## HALLWAY PROPERTIES LIMITED

### PROPOSED RETAIL DEVELOPMENT, WATERSMEAD BUSINESS PARK, LITTLEHAMPTON

#### TECHNICAL NOTE 4.0 - RESPONSE TO WSCC COMMENTS OF 4<sup>TH</sup> JULY 2025 10.09.2025

title
**PROPOSED HIGHWAY IMPROVEMENTS
AND SITE ACCESS ARRANGEMENT**

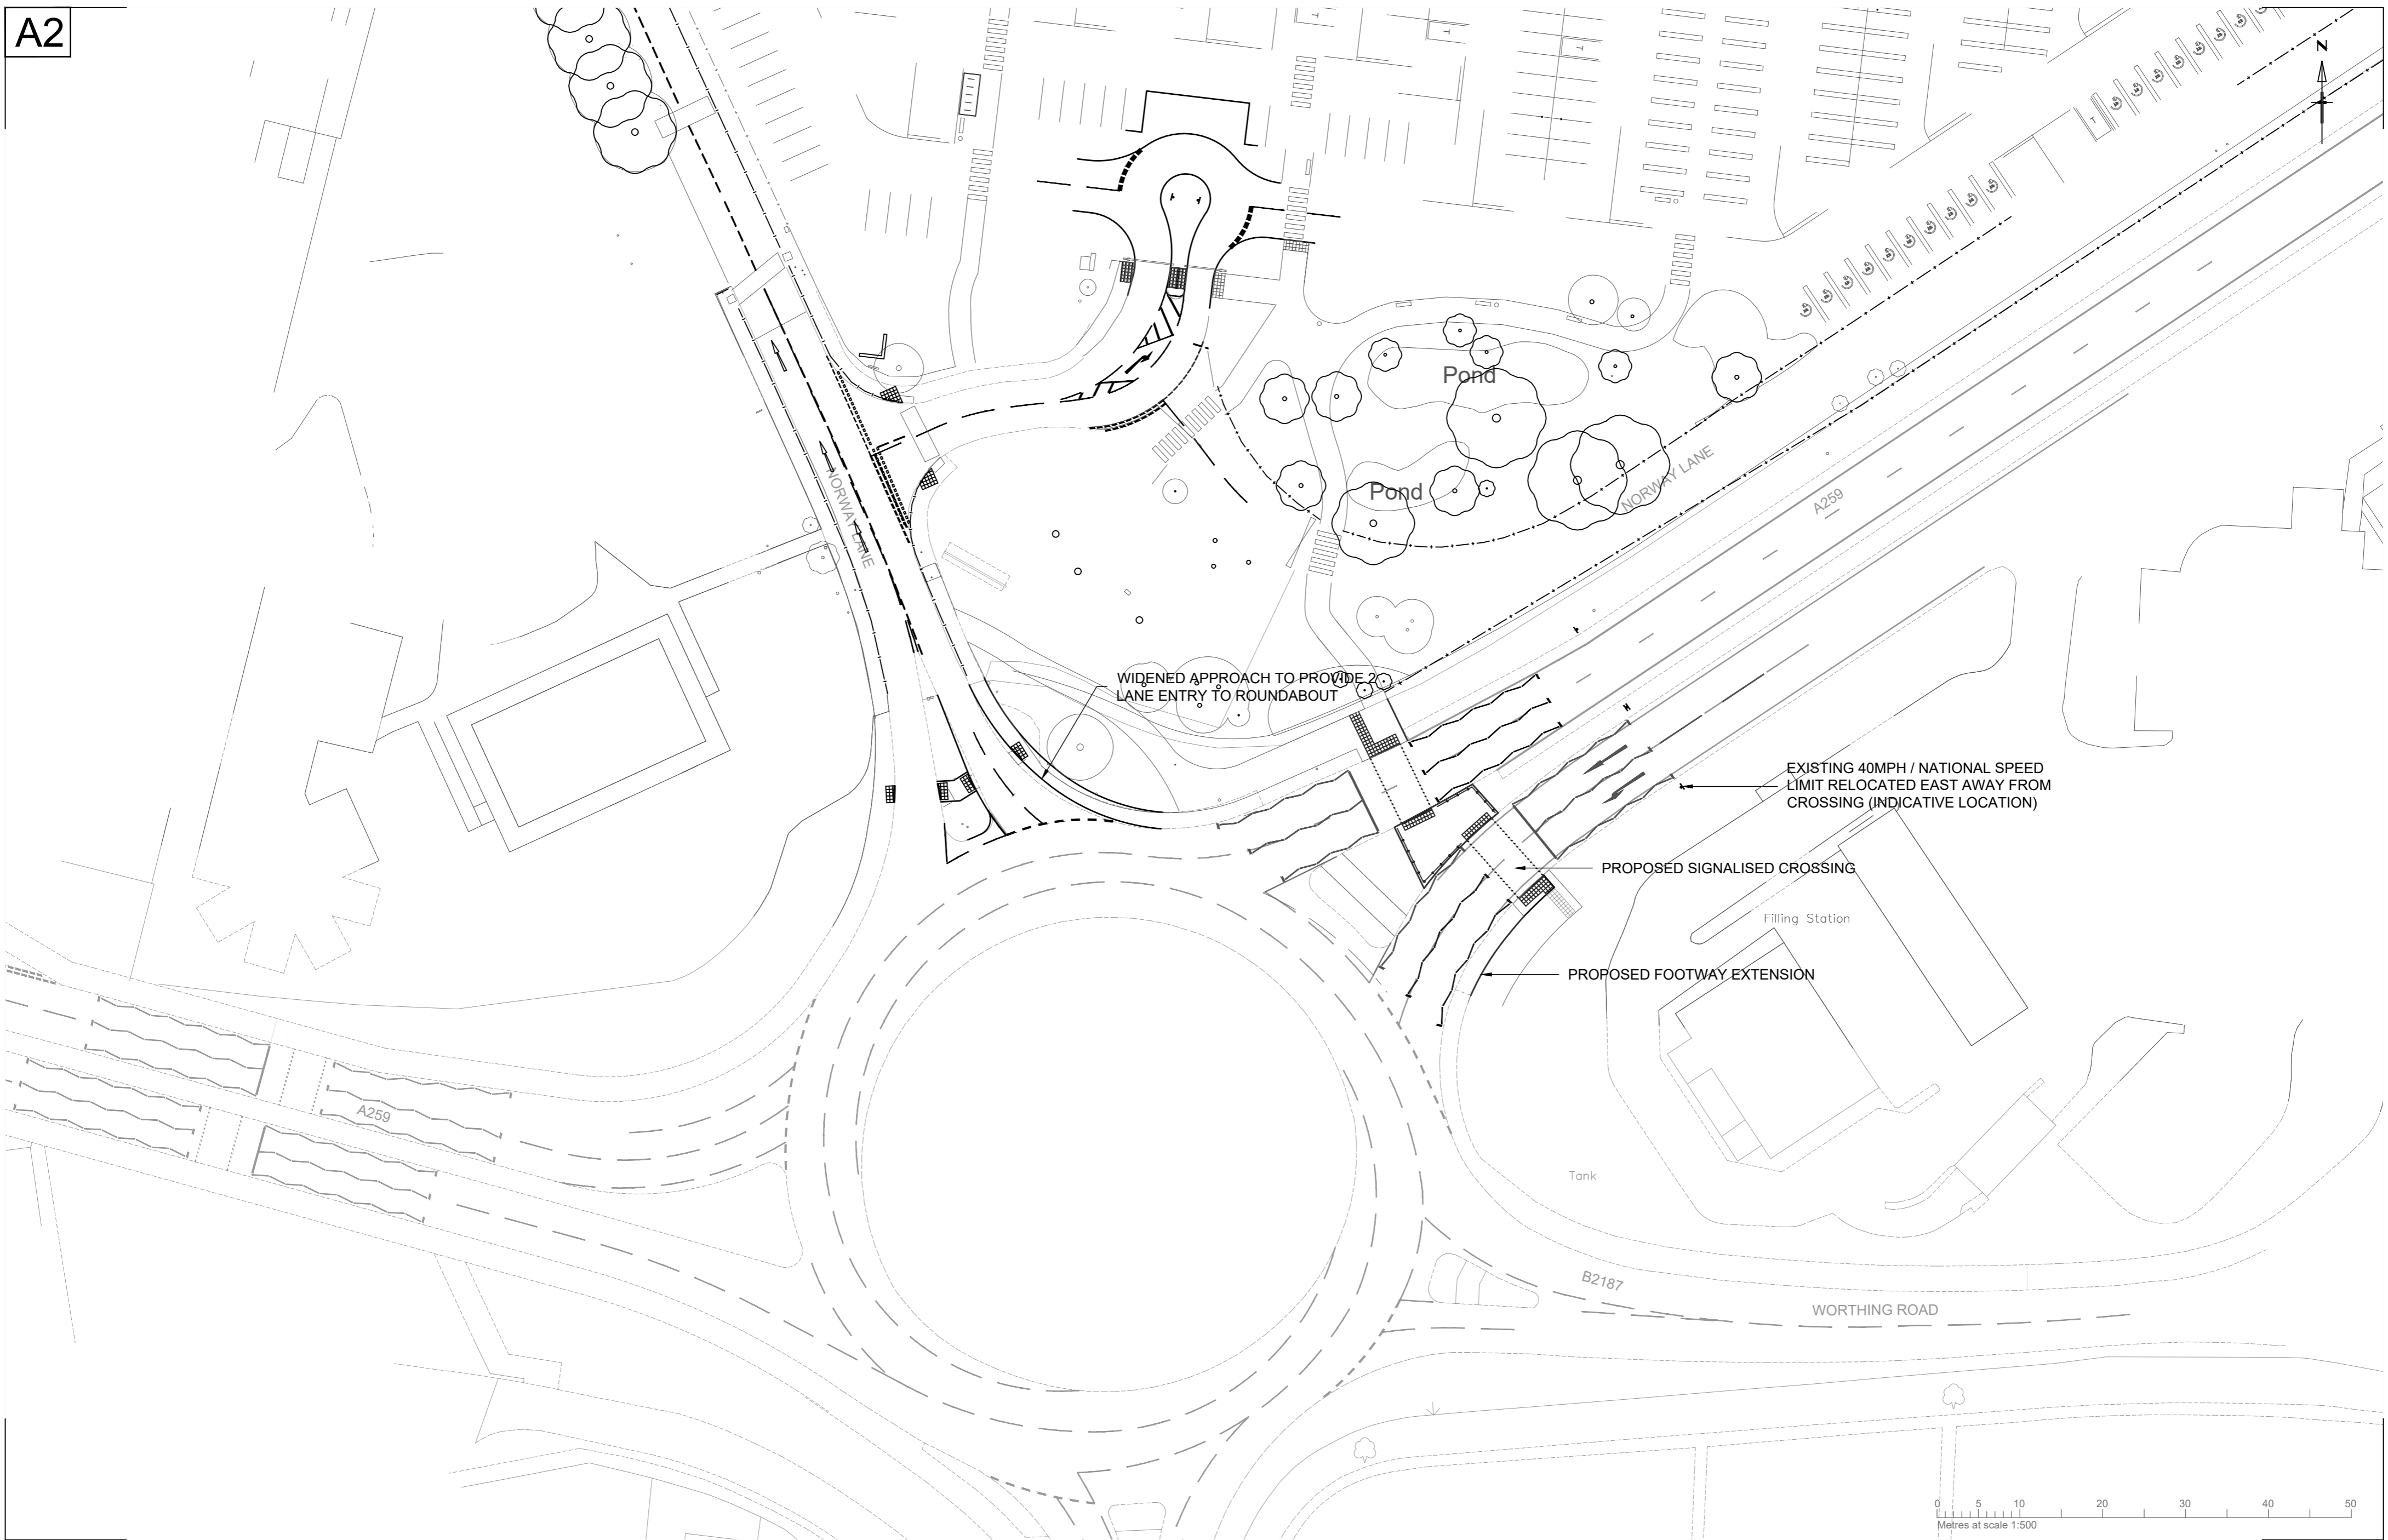
- 2.1 On page 2 of the comments, WSCC ask for a dimensioned drawing(s) that:
  - a) Show existing and proposed road widths on Norway Lane, along with proposed radii.

- b) Show the width of footways within the vicinity of the site, including those that route through the landscaped area to the south to establish route consistency.

- 3.1 WSCC offer a set of helpful comments to improve the Toucan crossing. They request that a maintenance lay-by be shown, and request that a 3m offset be incorporated into the design of the crossing.
- 3.2 The above have been incorporated into drawing 24084- 010 – C which can be seen at Appendix 1. A 3m offset has been incorporated into the crossing as well as a maintenance lay-by on the northbound side of the A259.
- 3.3 WSCC also offer detailed comments on minimising 'see-through' of the green man from the opposite side of the crossing. This is typically a detailed design matter which is capable of being resolved by the alignment of signal equipment.

- 2.2 The drawing covering a) and b) above can be seen at Appendix 1.
- 2.3 In summary, Appendix 1 shows:
  - Footway/cycleway provision is shown at 3m. The 3m width is aligned with the existing provision on the western side of the A259 near to the site. The concept of providing 3m is to ensure route continuity throughout.

- The 3m provision is concentrated around the northern side of the roundabout and through the landscaped area to the south of the site.
- 2.4 WSCC also request a swept path analysis of the secondary, northwestern car park access along with confirmation of visibility splays at the access. Norway Lane is subject to traffic calming via a series of speed cushions. Therefore a speed limit of 20mph has been assumed which would necessitate a 25m sightline, inclusive of bonnet length.

- 7.1 The changes above have resulted in the highways works drawing that was submitted in the Transport Assessment, 24084- 010 – A, being updated to that shown at Appendix 1, which is 24084- 010 – C.
- 7.2 Similarly the architects site plan has been updated to include the changes reference in this note, this can be seen at Appendix 3.
